KITITAS COUNTY

MEMORANDUM

TO: All Staff
FROM: Justin Turnbull, County Surveyor 
DATE: August 12, 2019
SUBJECT: County Survey Review of BLA BL-19-00015 Santa

RECORD OF SURVEY
 WITHIN A PORTION OF THE SW 1/4 OF SECTION 21,
 TOWNSHIP 20 NORTH, RANGE 14 EAST, W.M.,
 KITTITAS COUNTY, WASHINGTON

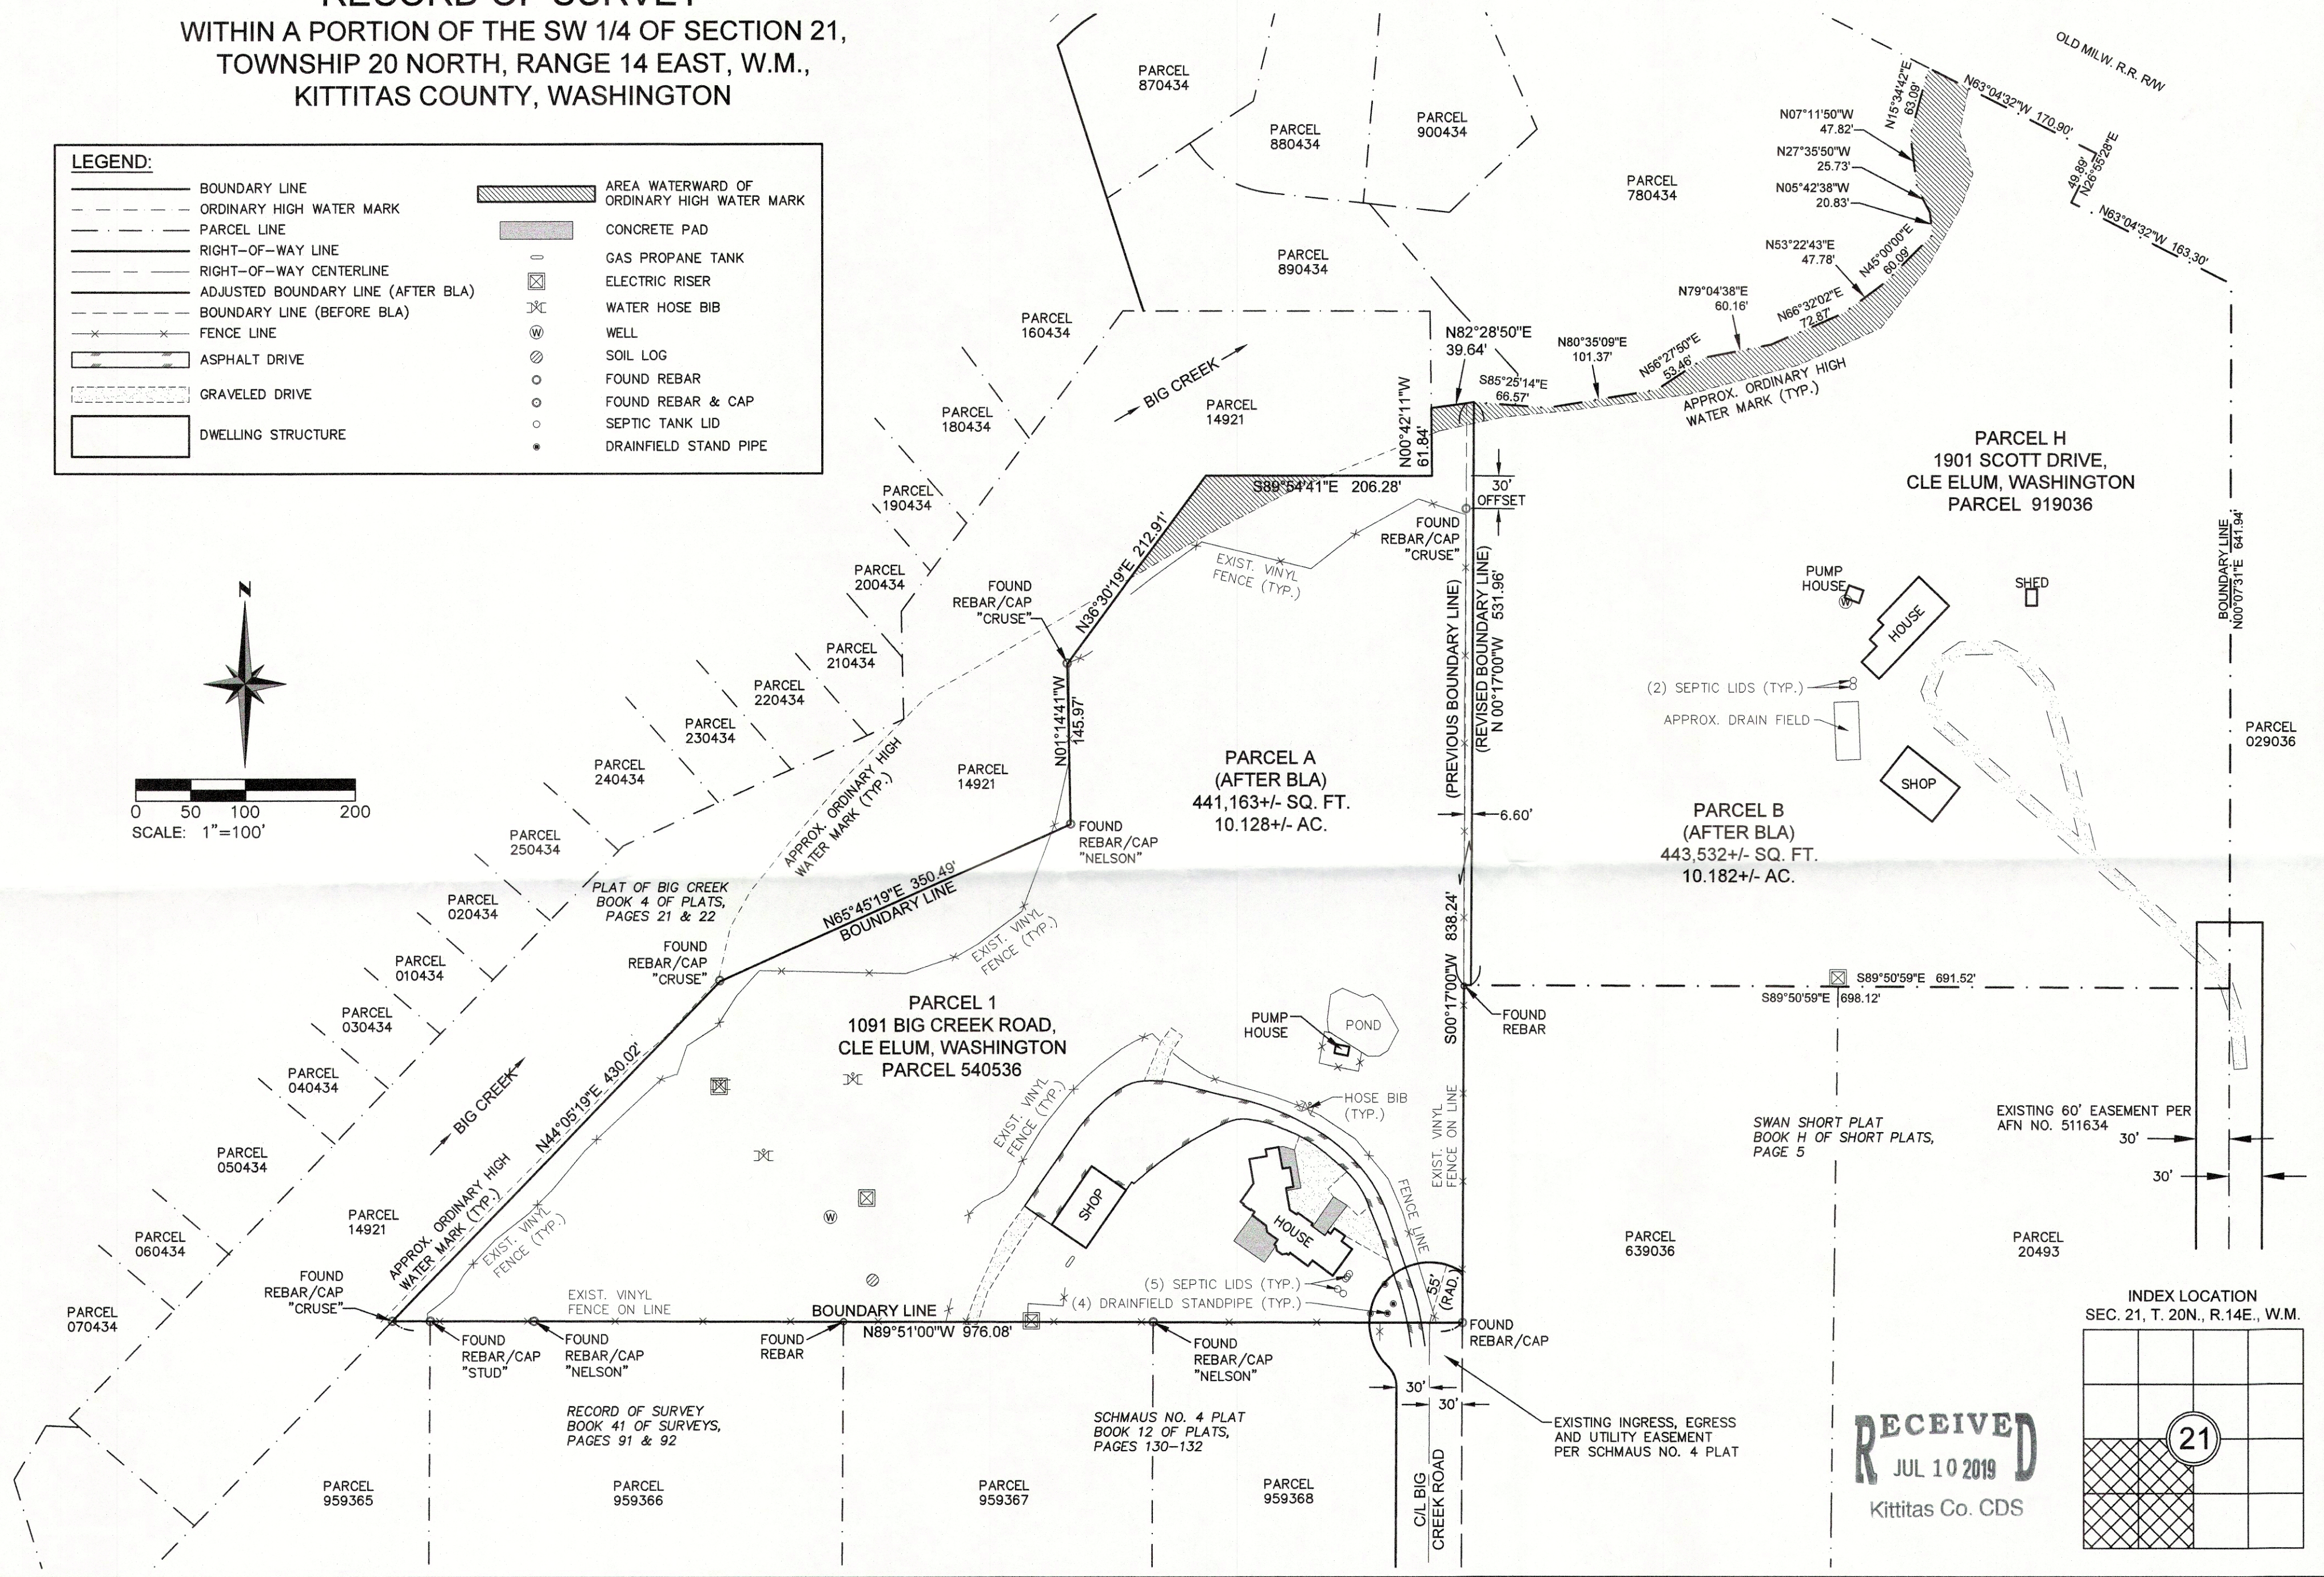
1. The basis of bearing statement refers to a line not shown on the face of the survey. A suitable alternative would be something similar to the following:
"The Basis of Bearing is the South line of Parcel 1, taken to be N89°51'00"W, per the survey recorded in Book 17 of Surveys, at Page 16, Records of Kittitas County."
2. Page one contains some grayscaled topo features. No grayscale lines should be shown on the recorded document.
